22/04/11

Department of Planning
Major Projects Assessment
GPO Box 39
Sydney NSW 2001
Attention: Heather Warton

Your Reference: **MP08_0116 Mod 1**
Subject: **Proposed Works: Relocation of overhead power lines from the rear of residential properties to the existing power line along Cooper Rd Potts Hill and the replacement of polls along the existing Cooper Rd power line.**

BIRONG - COOPER ROAD
132kV FEEDER 240
OVERHEAD MAINS RELOCATION
ROUTE PLAN & CONSTRUCTION SCHEDULE

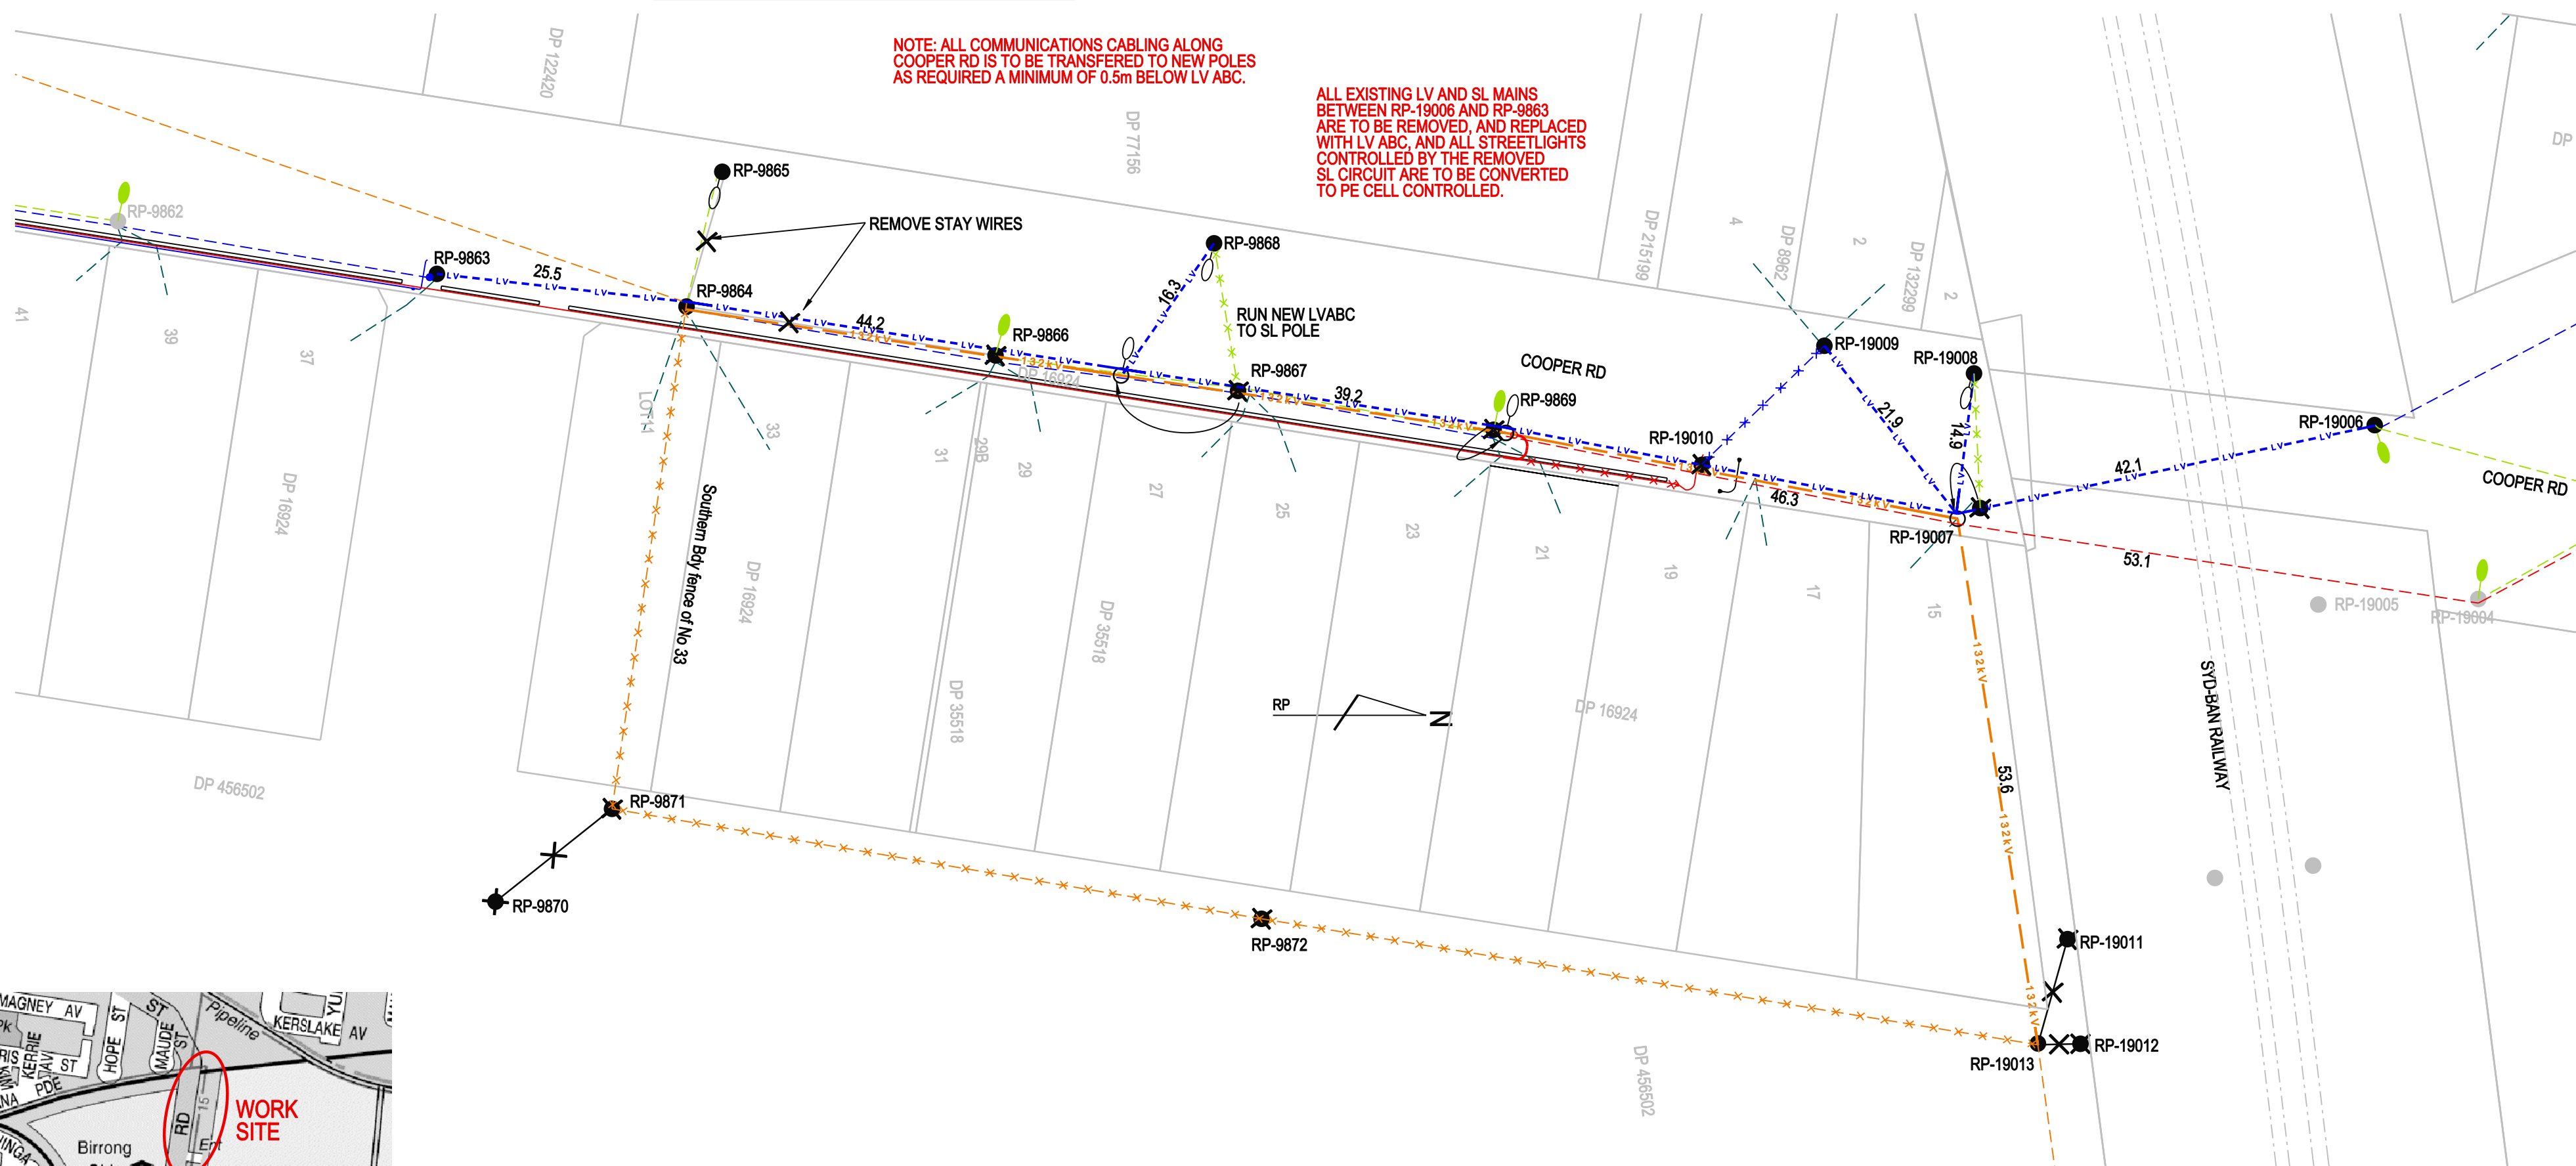
Sydney Water has **3000mm trunk watermain within the vicinity** of the abovementioned area and it appears that Sydney Water's assets may be affected by the proposal (see attached plan). The Corporation's investigations have been based on Drawing No. **221465** (Energy Australia) and it appears that Sydney Water's assets may be affected by the proposal.

Please advise the applicant to engage an authorised Water Servicing Coordinator (the Coordinator) to lodge and manage an application to enable Sydney Water to determine and issue the requirements. If you have completed a detailed design, which ensures all clearances have been met, please forward these for further assessment.
